**Marine
Management
Organisation**

MMO Reference: DCO/2021/00002
Planning Inspectorate Reference: EN010119
Identification Number: 20051047

24 June 2025

Planning Act 2008, Proposed North Falls Offshore Wind Farm Project Order Deadline 6 Submission Summary

Appendix B. Plots for Comparable Hammer Strike Energies

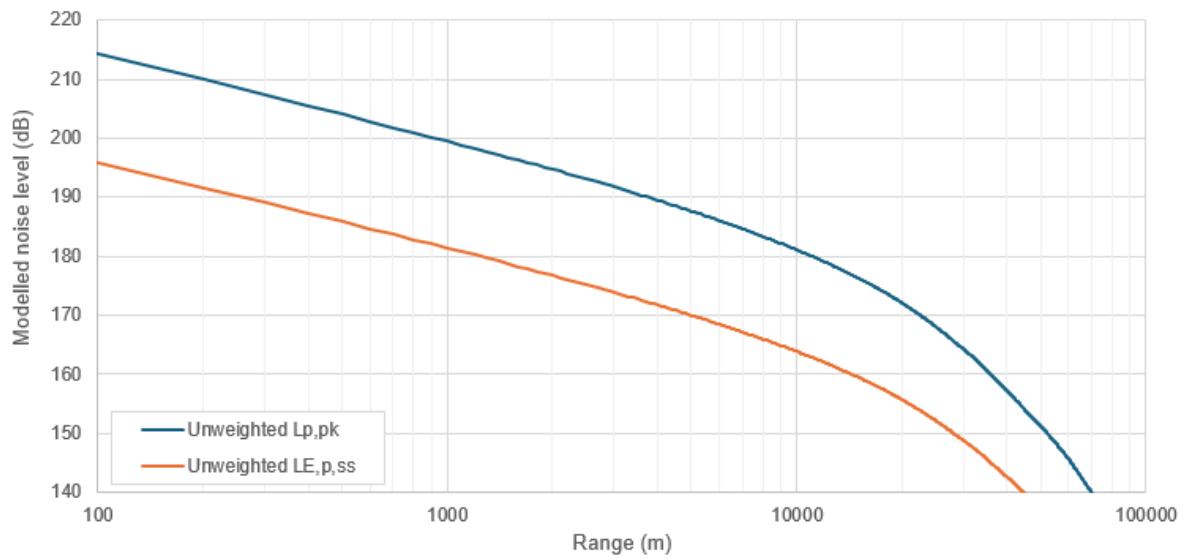
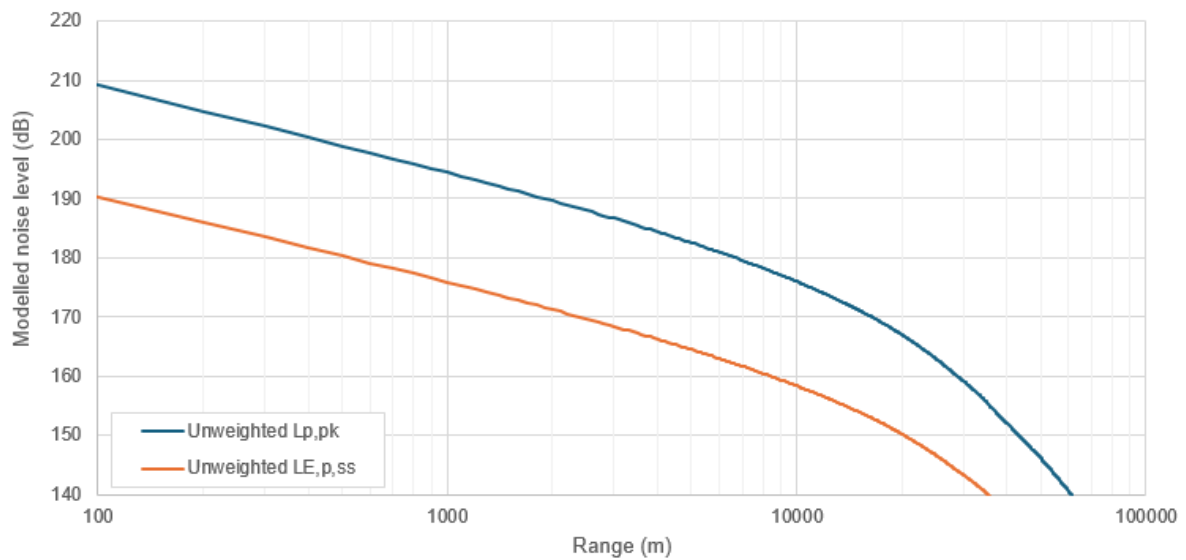
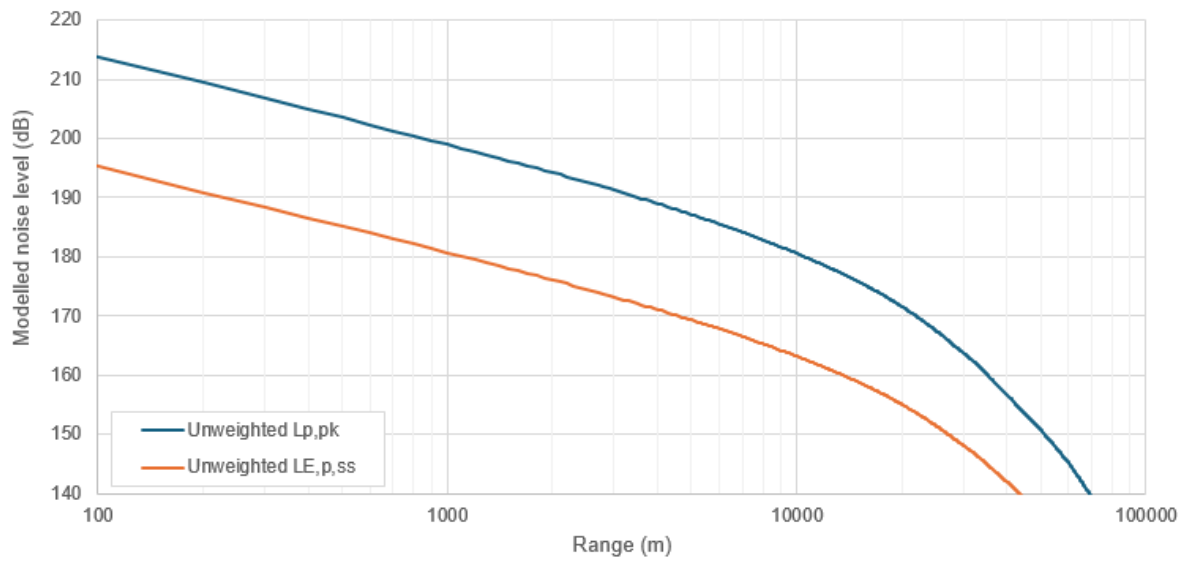
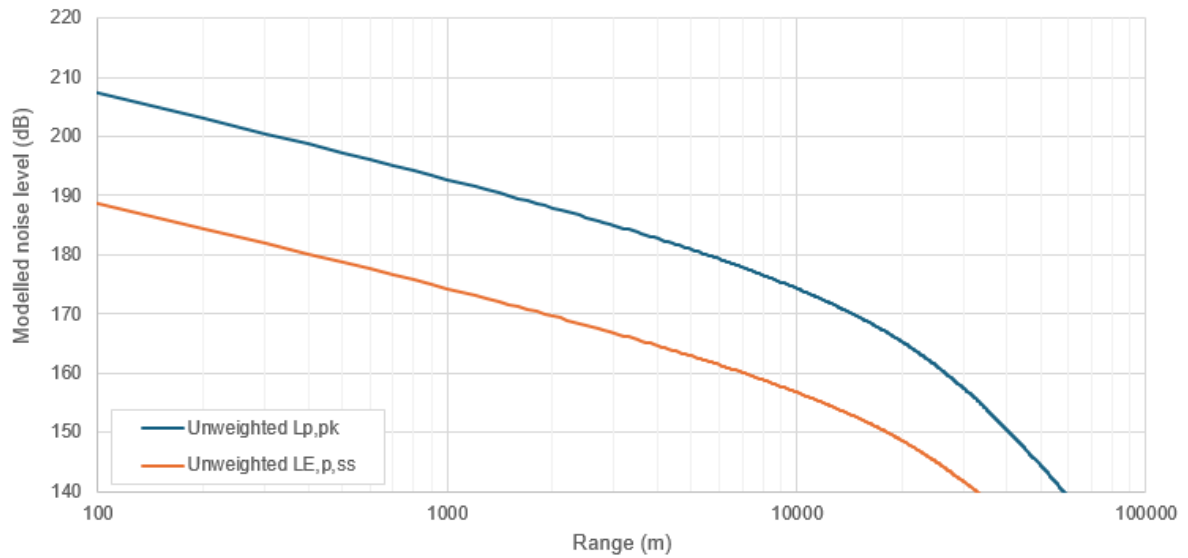
4.4 REP4-079_j - 4.2 Comments on the updated Draft Marine Mammal Mitigation Protocol (MMMP) [REP3-014 – Tracked] (Para 4.2.1-4.1.17)

4.4.3 The MMO is content with the plots for Comparable Hammer Strike Energies provided in Appendix B.
